WEST SUSSEX COUNTY COUNCIL CONSULTATION

TO:	Arun District Council FAO:
FROM:	WSSC – Highways Authority
DATE:	3 March 2026
LOCATION:	25 River Road Littlehampton BN17 5BZ
SUBJECT:	LU/29/26/PL Demolition of existing garage/offices with associated hard standing and construction of 2 No residential building comprising of 3 No one bedroom houses and 1 No two bedroom house. This application affects the character and appearance of the Littlehampton (River Road) Conservation Area and is in CIL Zone 4 and is CIL Liable as new dwellings.
DATE OF SITE VISIT:	n/a
RECOMMENDATION:	No Objection

Proposed Site Plan (NTS)

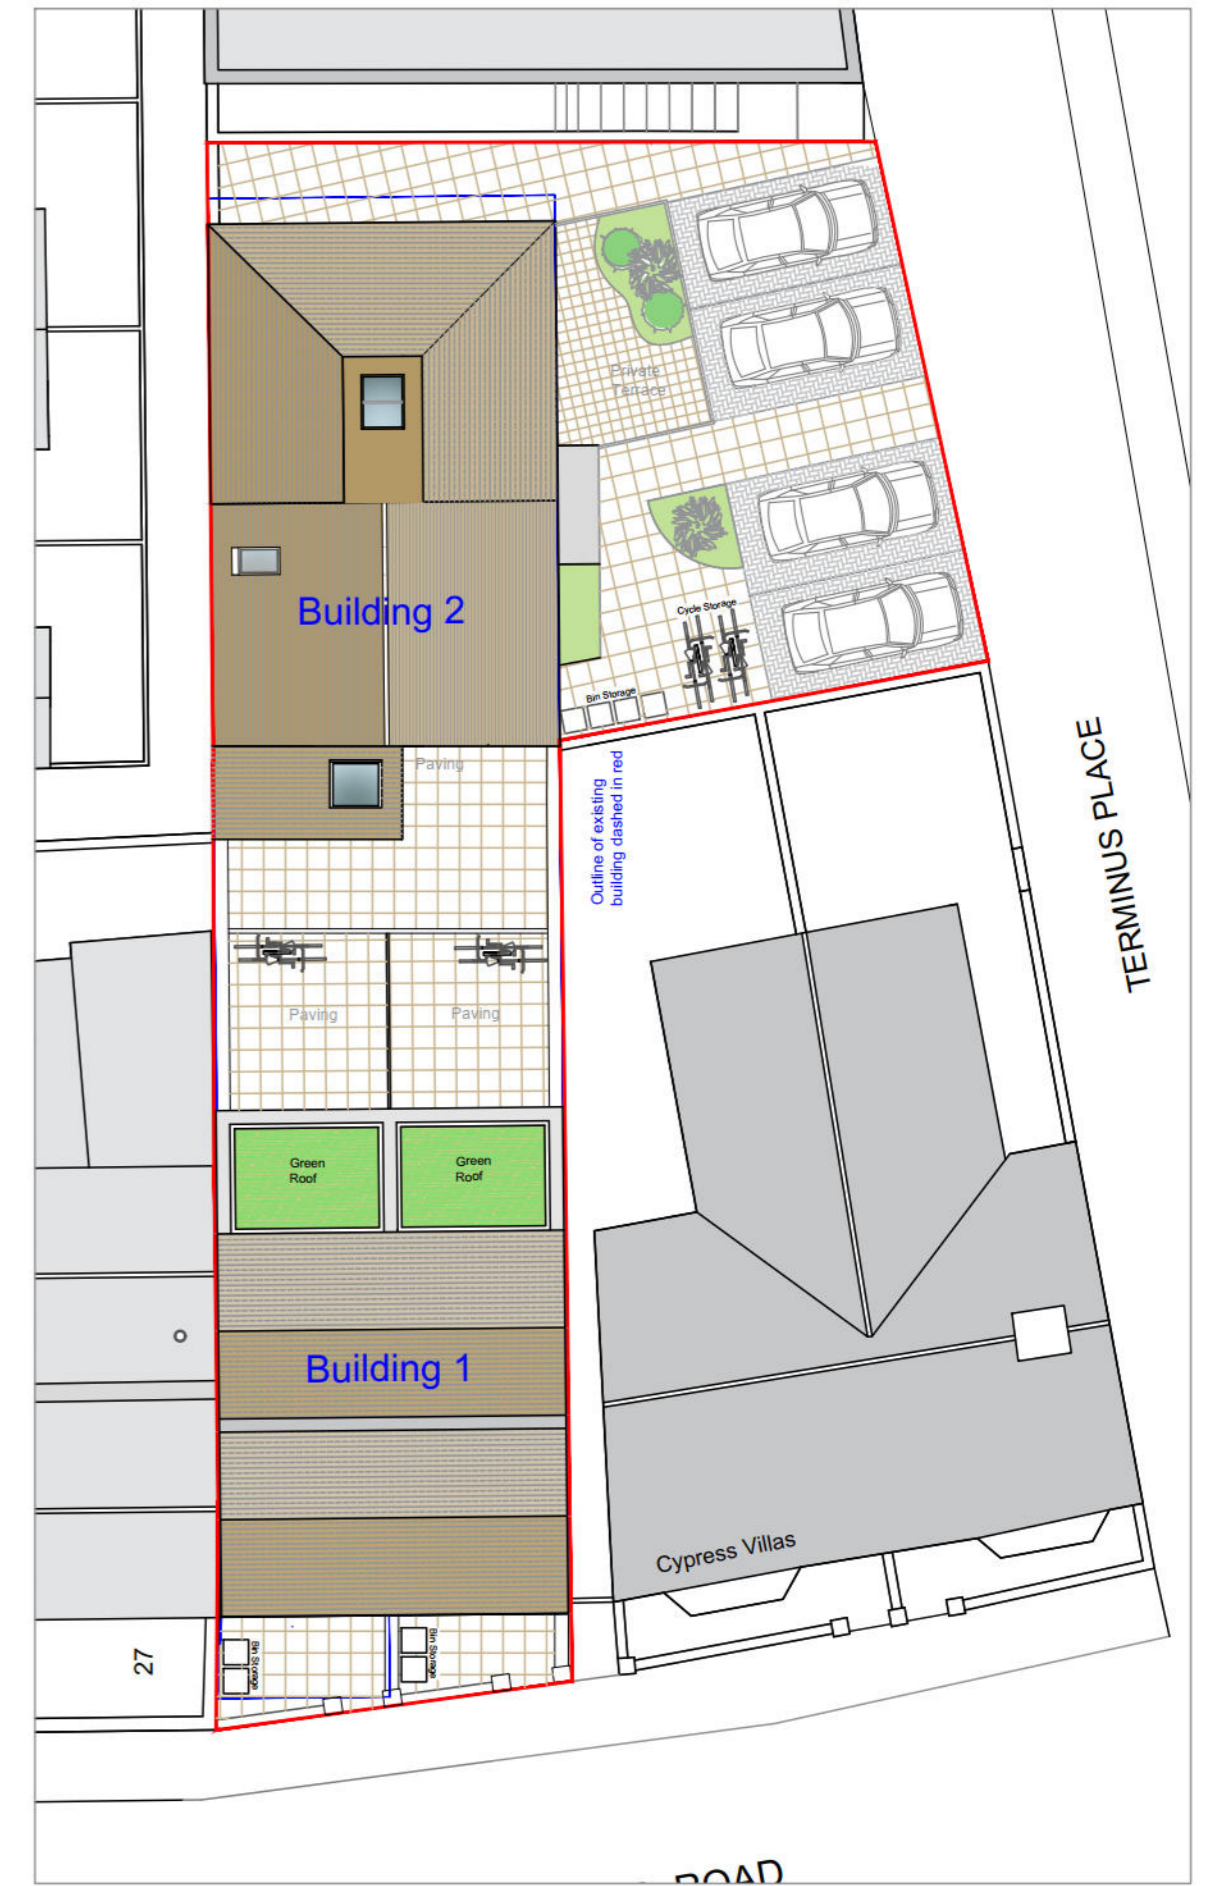
This application includes 4 car parking spaces with direct access onto Terminus Place. Whilst this sort of parking arrangement is not optimal and may involve vehicles reversing onto the highway, this is the current position for the existing use. In addition, the existing use as a servicing and repairs garage is likely to have generated higher levels of vehicle manoeuvres over the proposed residential use. It is also very likely that residents will reverse into the parking spaces so as to enter the highway in a forward gear.

No part of the development shall be first occupied until such time as the vehicular access serving the development has been constructed in accordance with the details shown on the site plan drawing.

No part of the development shall be first occupied until the car parking has been constructed in accordance with the approved site plan. These spaces shall thereafter be retained at all times for their designated purpose.
